**RESPONSE TO REQUEST FOR ADDITIONAL INFORMATION
SSD-11429726 – EDEN STREET COMMUNITIES PLUS**

This letter has been prepared by Ethos Urban on behalf of Arncliffe Eden Property Pty Ltd in response to the Request for Additional Information (RFI) issued by the Department of Planning and Environment (DPE) for SSD-11429726 dated 23 May 2022. This letter should be read with reference to the following appended documentation:

DA SUBMISSION				
Plotted and checked by	PDS			
Verified	PDS	Approved	LMC	
Drawing Created (date)		Drawing Created (by)	JK, SM, AR, EC, AF	
				14/10/2020
Scale	Project No	Drawing No	Issue	
1 : 600	180319	DA 4352	C

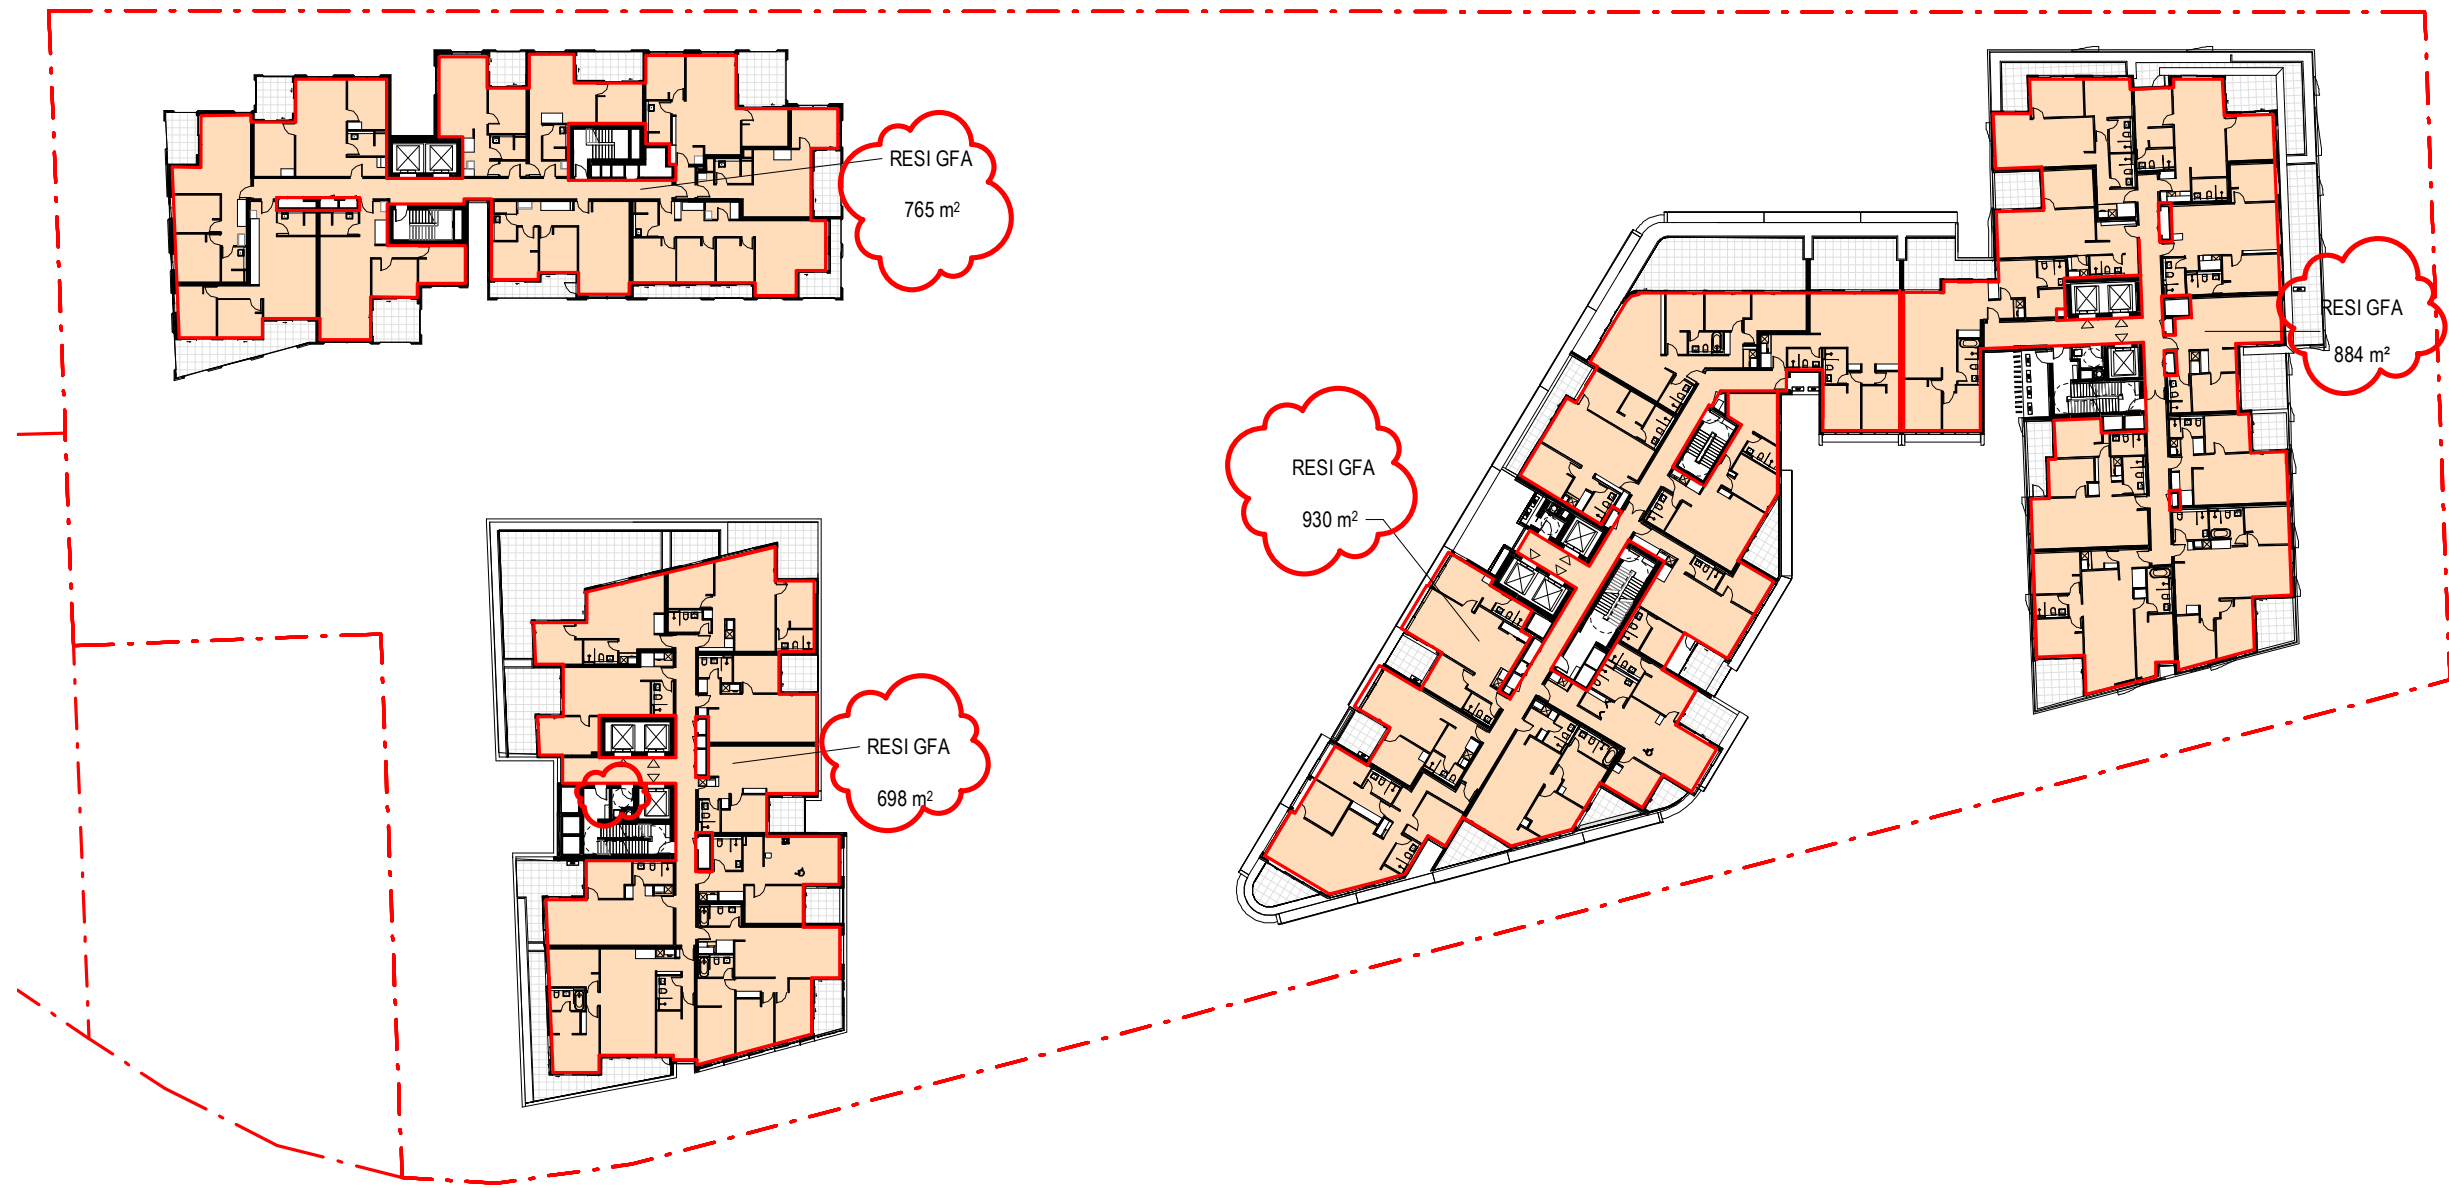
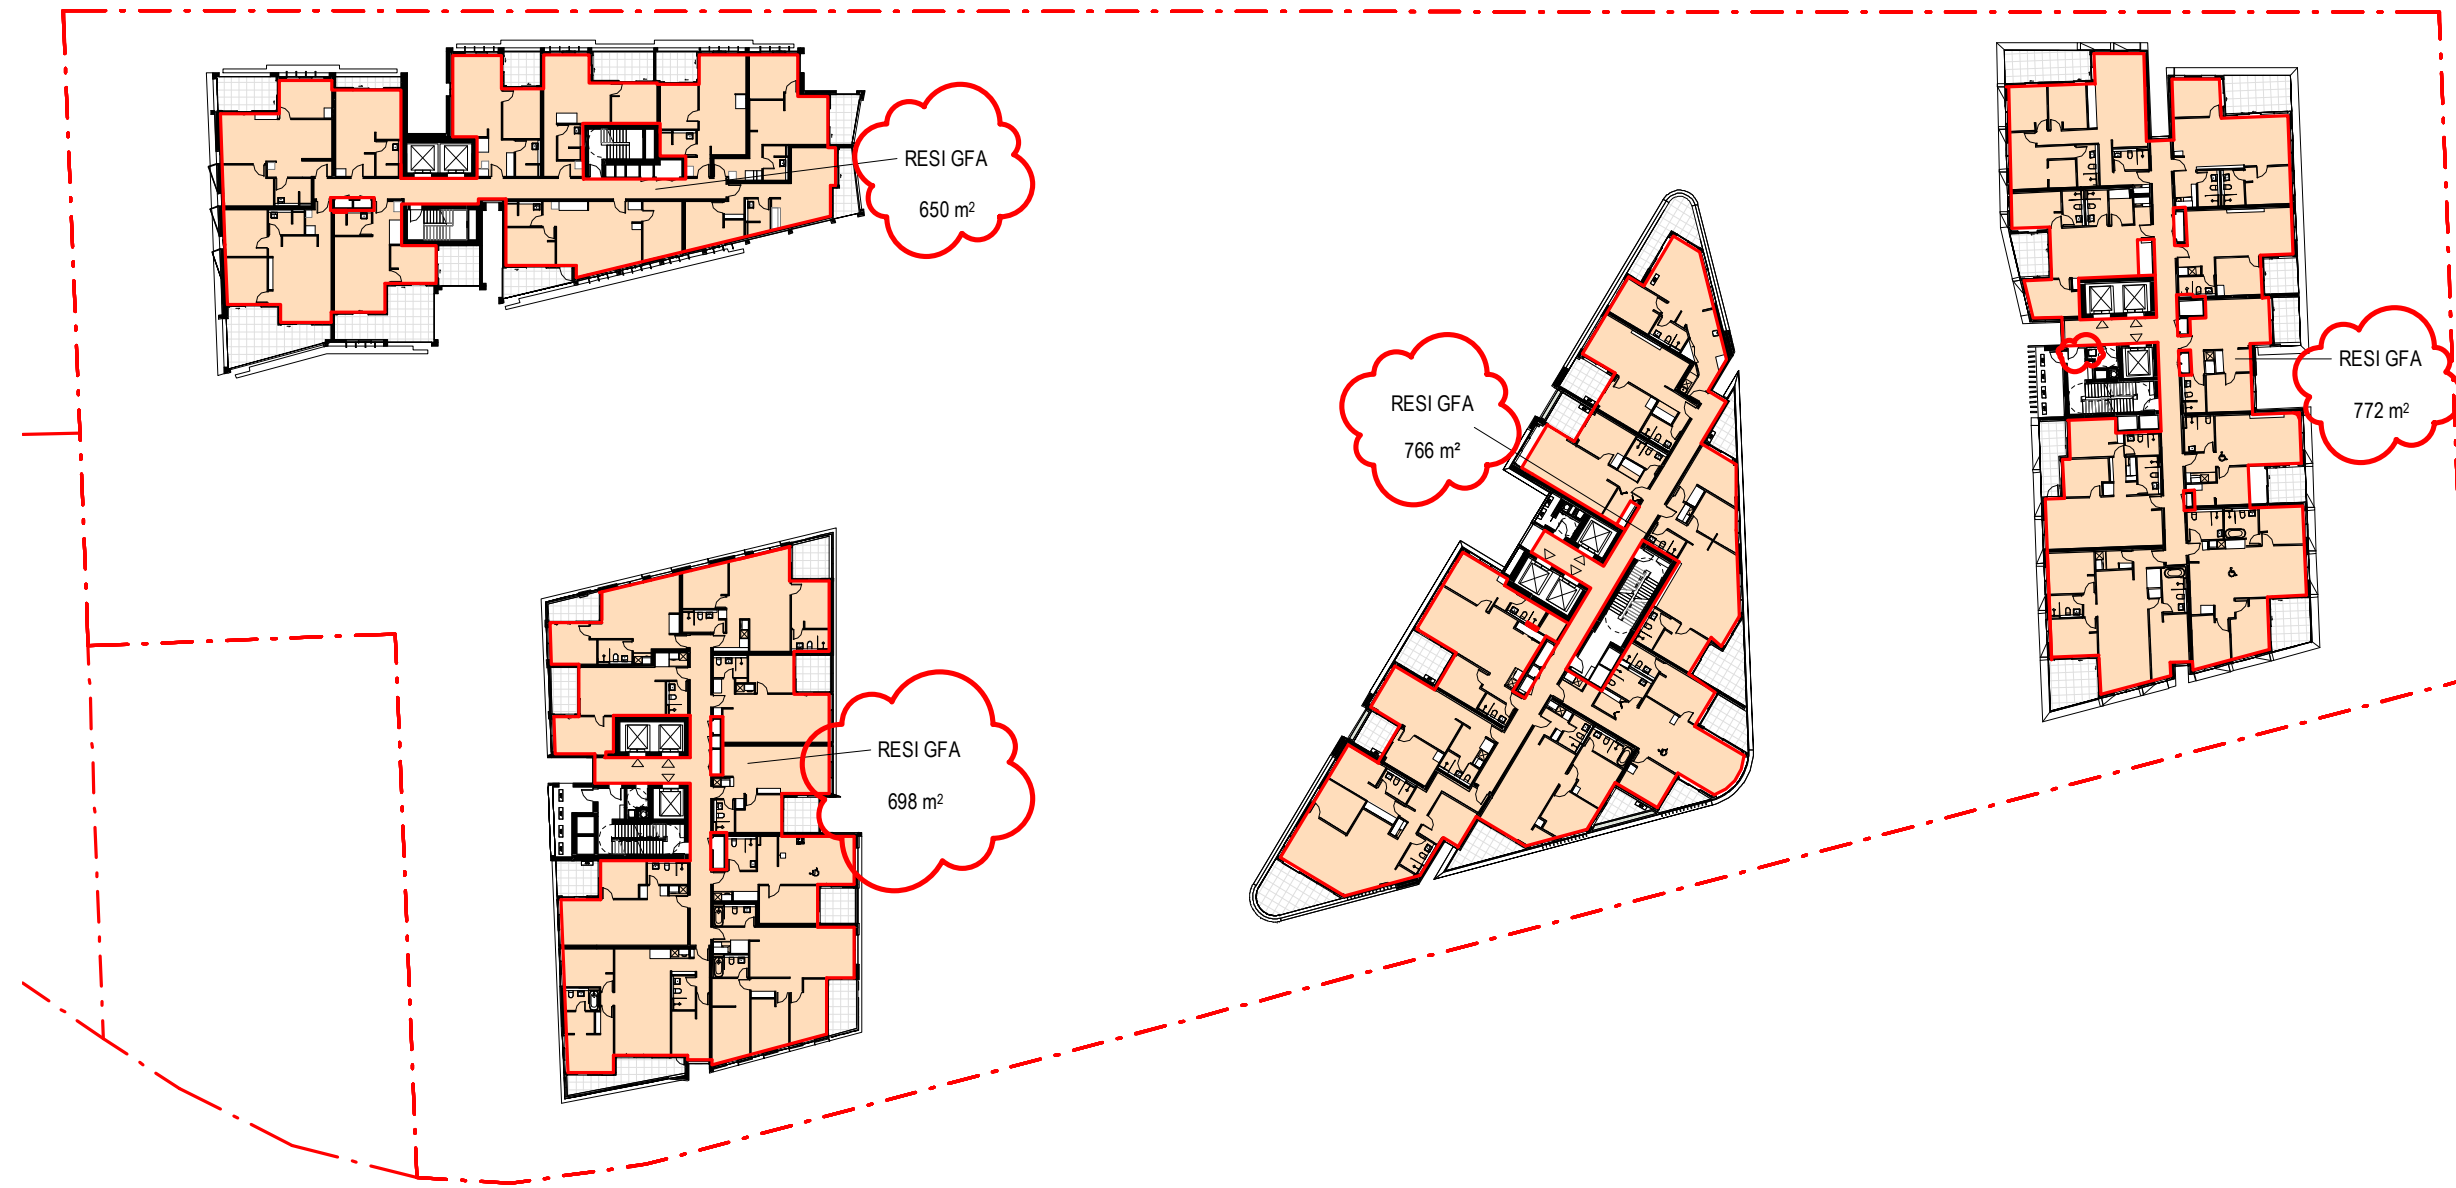
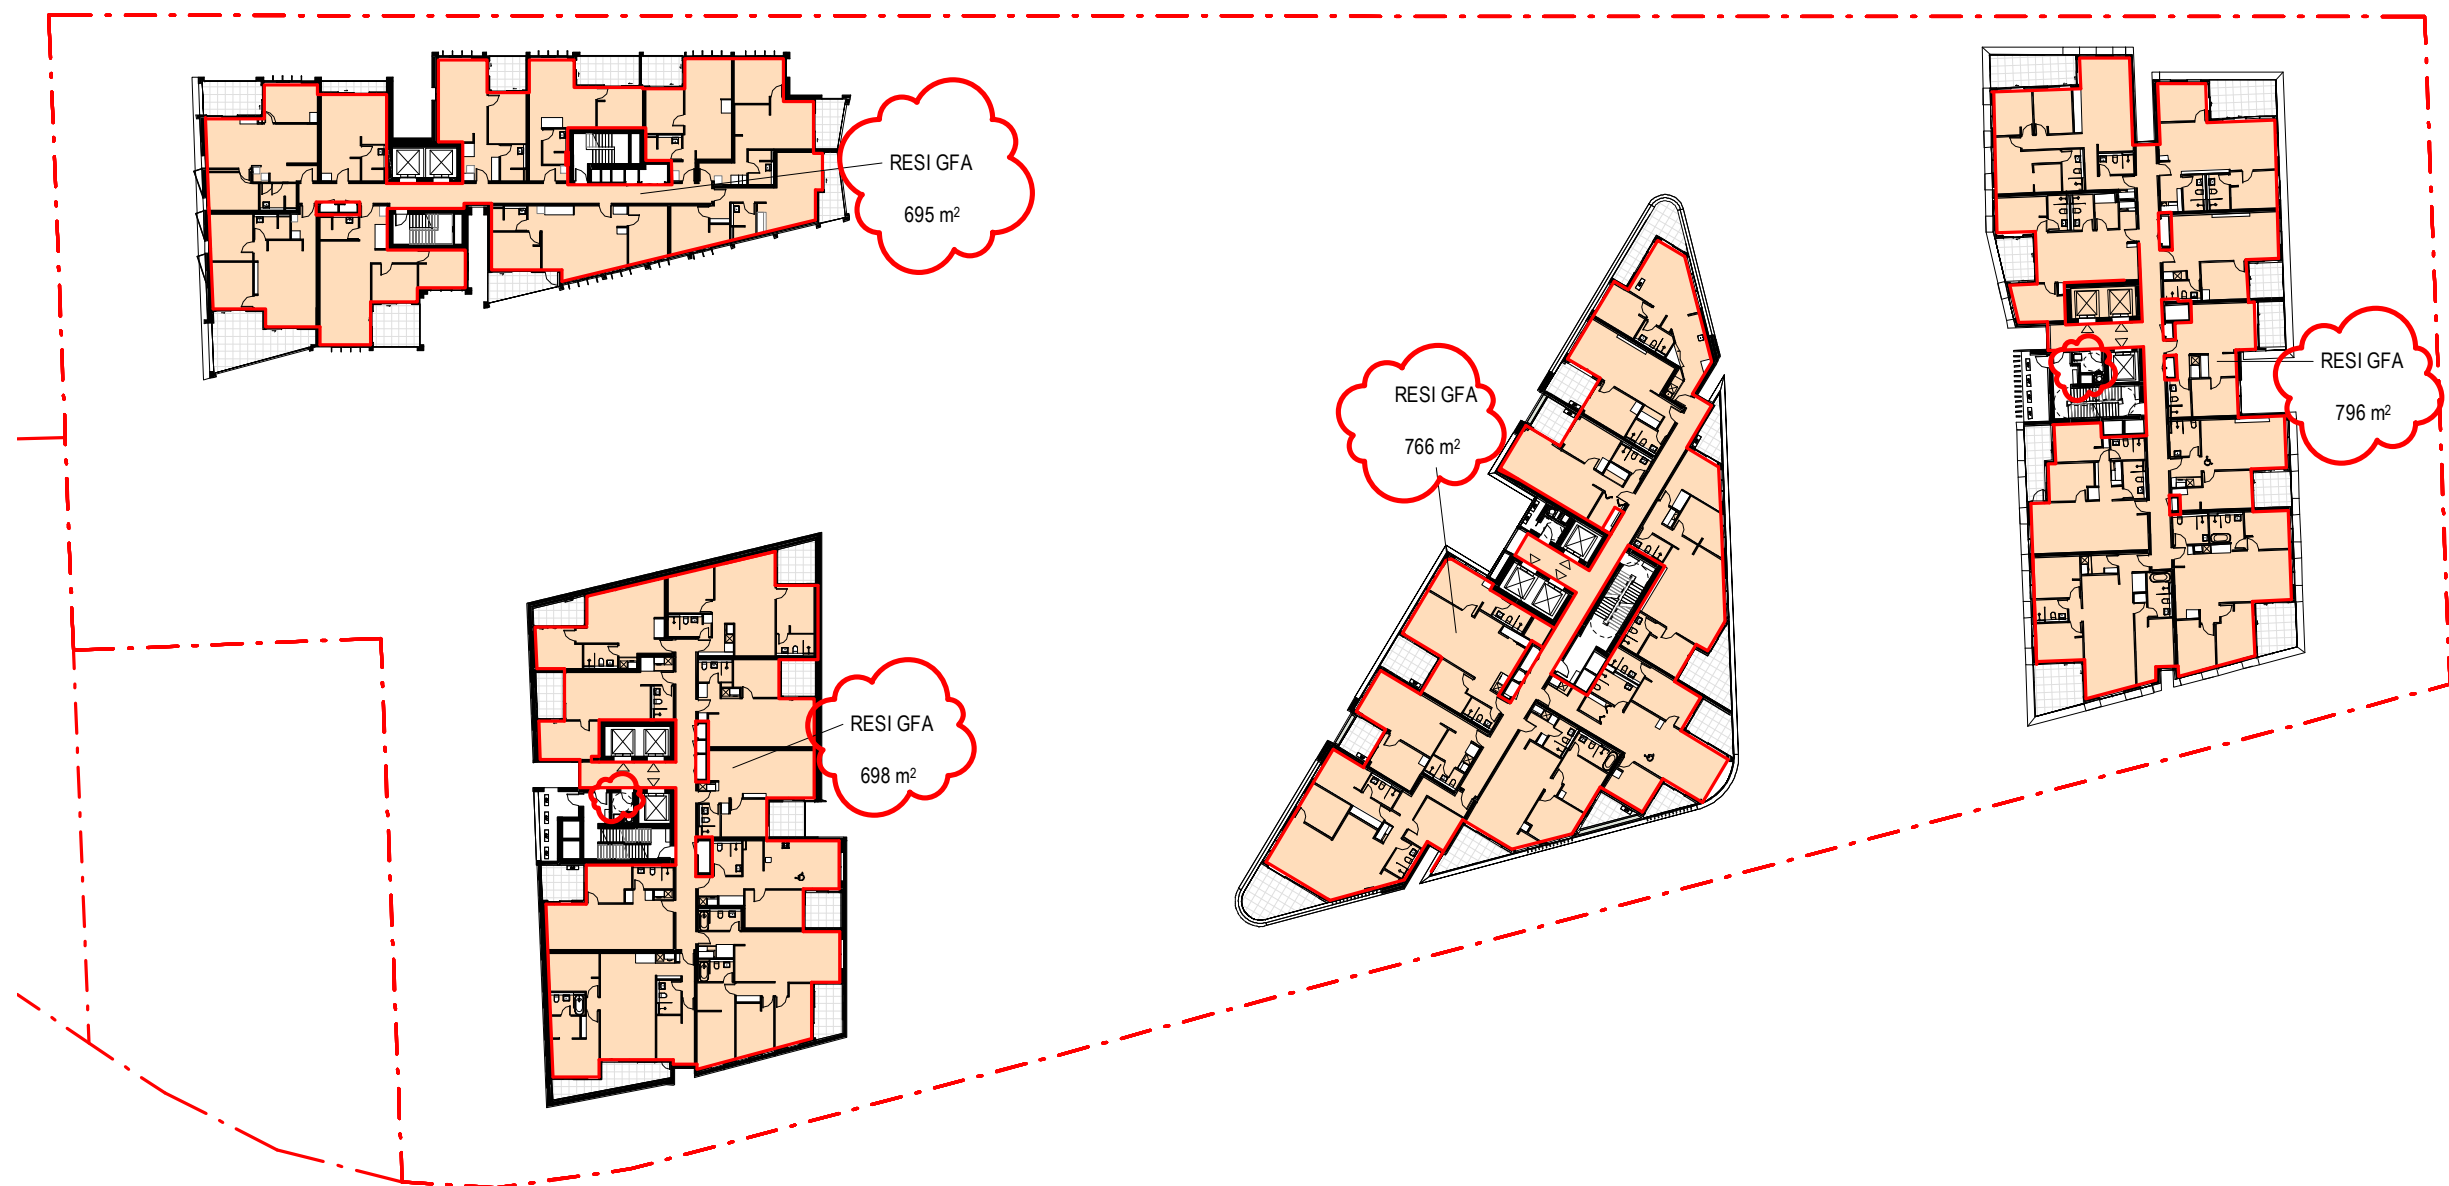
<p>7. Update the development summary table on drawing DA 0000 F to include wintergardens in the total GFA and FSR calculations.</p>	<p>Wintergardens have been included in GFA and FSR calculations.</p>
<p>8. Update the key on Drawing DA4101 to show 889m² of wintergarden instead of 848m².</p>	<p>Drawing DA4101 in Attachment B has been updated to show the correct wintergarden GFA.</p>
